Reference No:	2024/62/93564/W
Site Address:	20, Rowley Drive, Lepton, Huddersfield, HD8 0AH
Description:	Erection of single storey rear extension, front porch, dormers, demolition of garden buildings including hip to gable alteration to existing roof and associated alterations.
Recommending Officer:	Joshua Merriman

HOUSEHOLDER DELEGATED REPORT

Application Number	2024/93564
Location	20, Rowley Drive, Lepton, Huddersfield, HD8 0AH.
Proposal	Erection of single storey rear extension, front porch, dormers, demolition of garden buildings including hip to gable alteration to existing roof and associated alterations.
Publicity end date	20/02/2025
Number of representations received	None.
Kirklees Local Plan Allocation/Designation	The application site is located in a bat alert layer but is otherwise unallocated in the Kirklees Local Plan.
Extension to Time (EoT)	No
Recommendation	Conditional Full Permission

REV-B.GARDEN.BUILDING.REQUESTED.TO.BE.REMOVED.BY.CASE.OFFICER.&.TO.ALLOW.FOR.PD.GARDEN.BUILDING

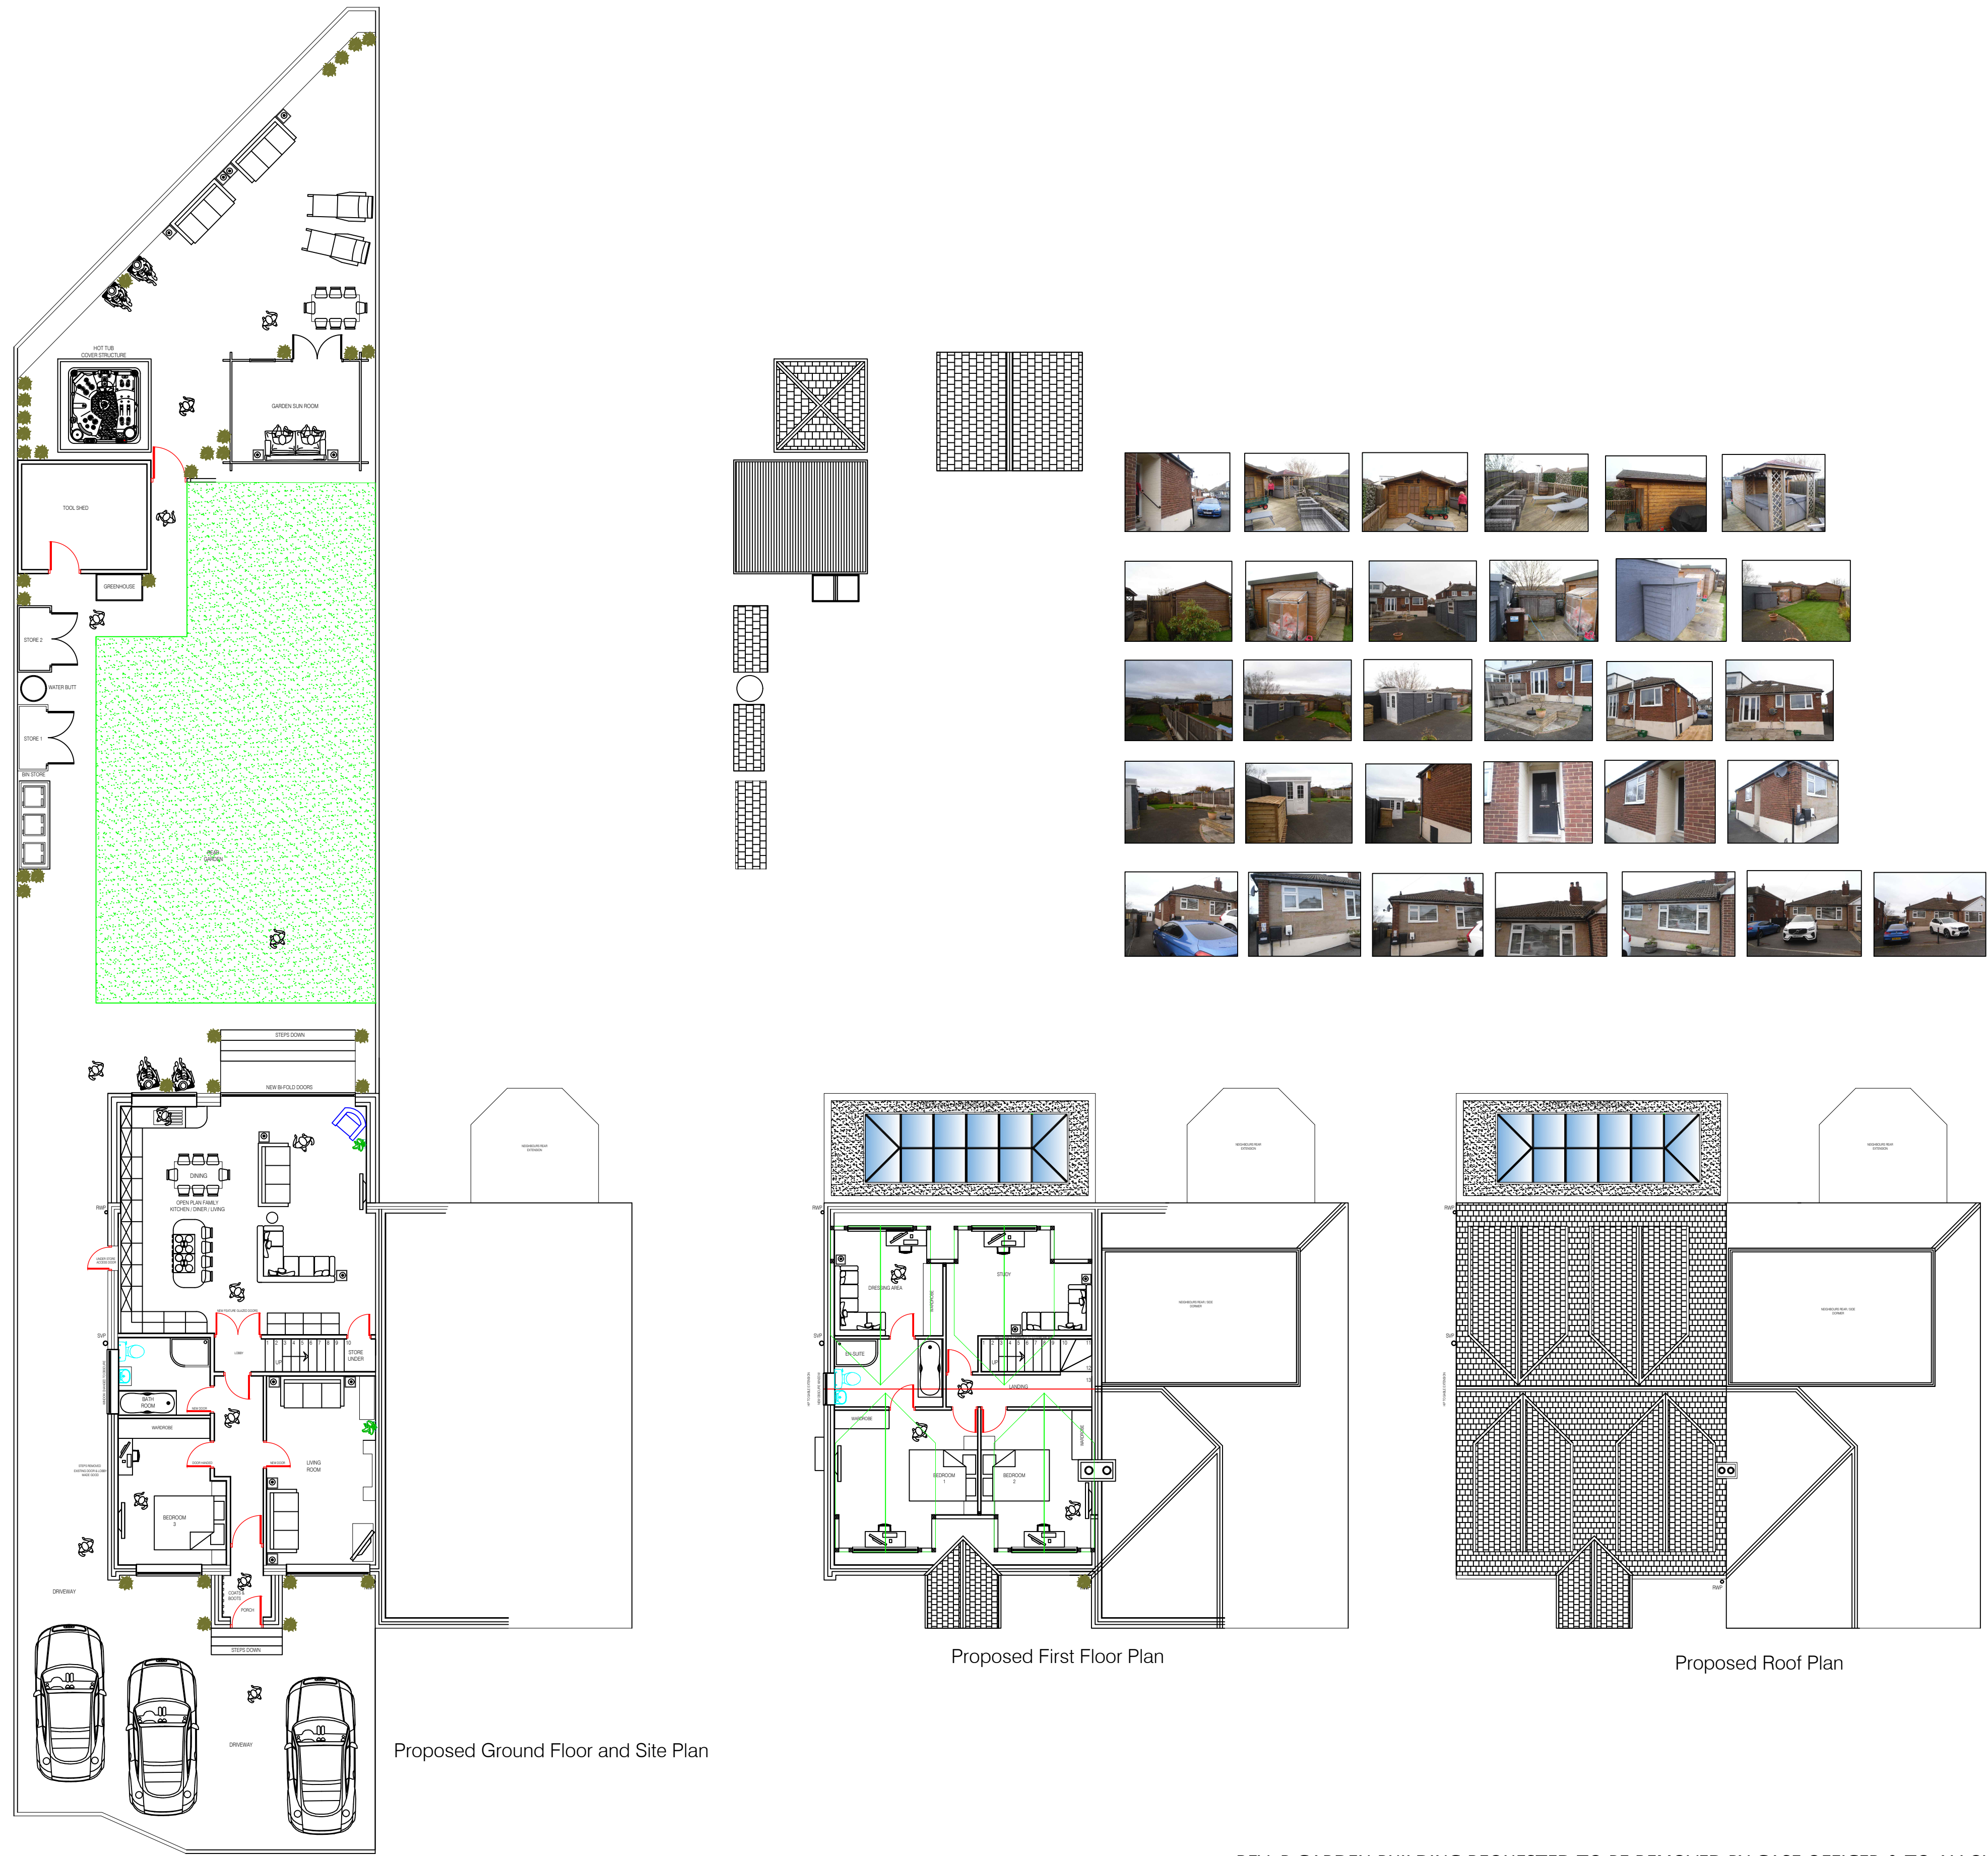
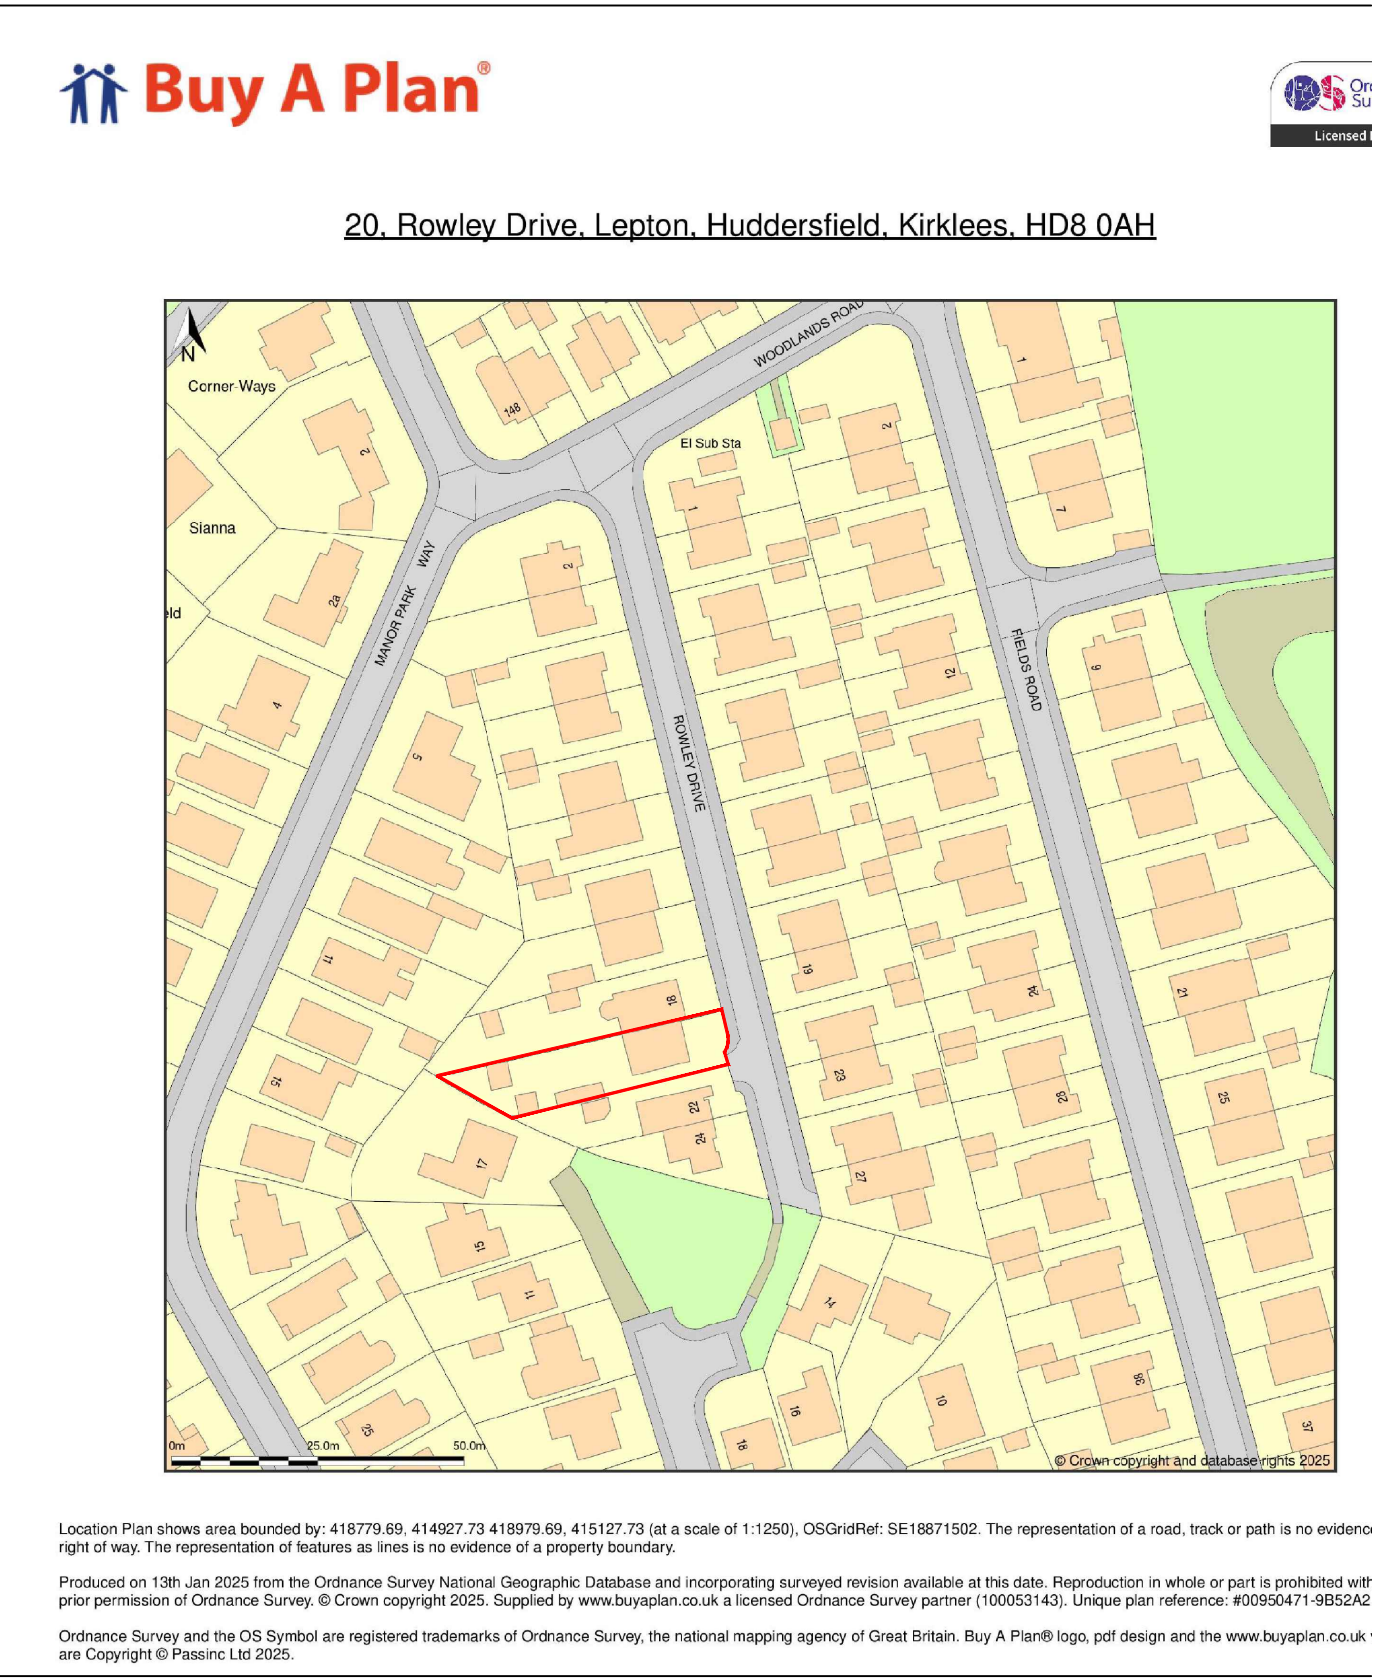
Negotiations/Amendments during course of application	Yes	During the course of the application, officers requested that the proposed outbuilding was removed from the proposals due to concerns regarding its resultant impact upon the residential amenity of the neighbouring occupants. An amended plan was received on this basis.
Parish/Town Council comments sought	No	
Planning History	No	
Consultations required	No
